Application number: 2025/92541	
What is the application for?:	Operational development to create development plateau comprising land level chan
Address of the site or building:	Land off, Roslyn Avenue, Netherton, Huddersfield, HD4 7EW
Postcode:

User comments

drawing title: Proposed Levels Plan Sheet 02			
Drawing Number: EE100008-203	Drawn by: SG	Checked by: SG	
Project ref: EE100008	scale: 1:250	date: 30.09.2025	original paper size: A1

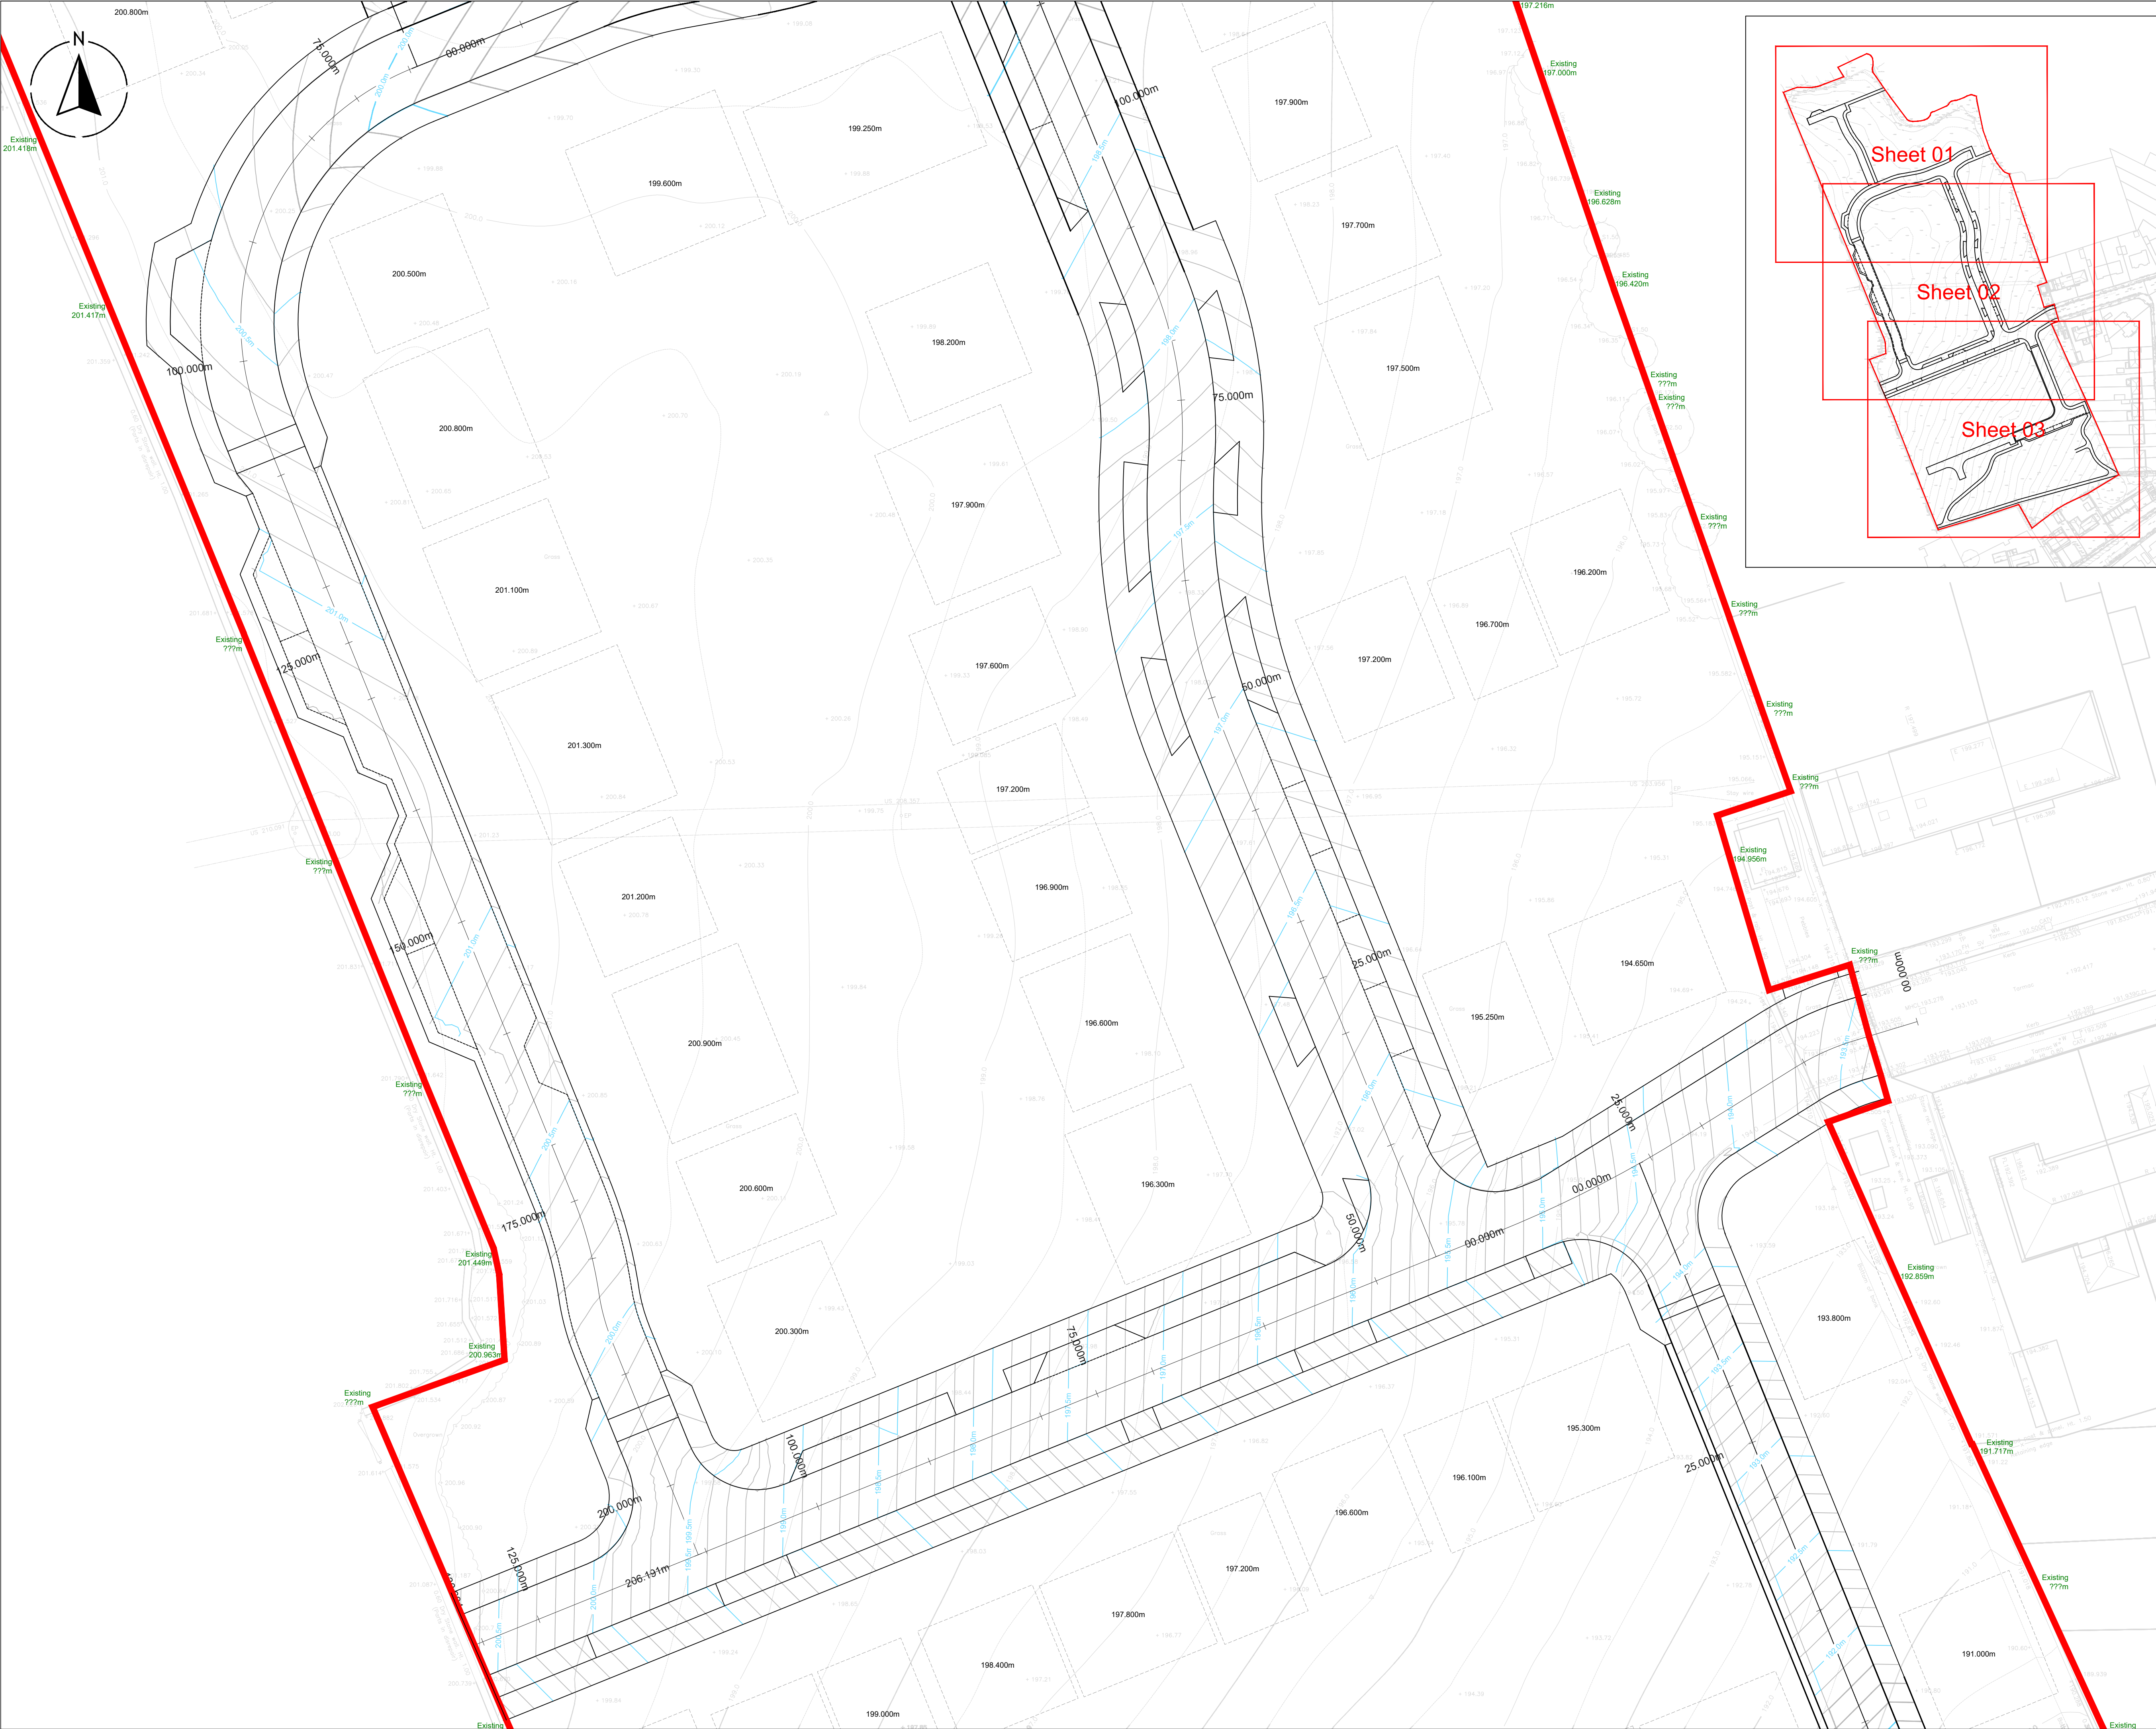
Type of comment: A general comment	
Do you wish your comments to be published on the website anonymously?	<input type="checkbox"/> Yes
<p>Dear sirs, it has been noted that the design levels shown along the sites south eastern boundary, adjacent to the existing properties. Stand quite substantially higher, than that of the existing. As does the new road layout behind these. Please could some sectional elevations be provided here. Further level information also appears to be a miss within this latest submission.</p> <p>I would also like to highlight that per the FRA there has been no resubmitted plans, outlining preventative measures that take into account the likelehood of overland flooding to the existing properties. Either during the construction phase or upon completion. Please could this be sought.</p>
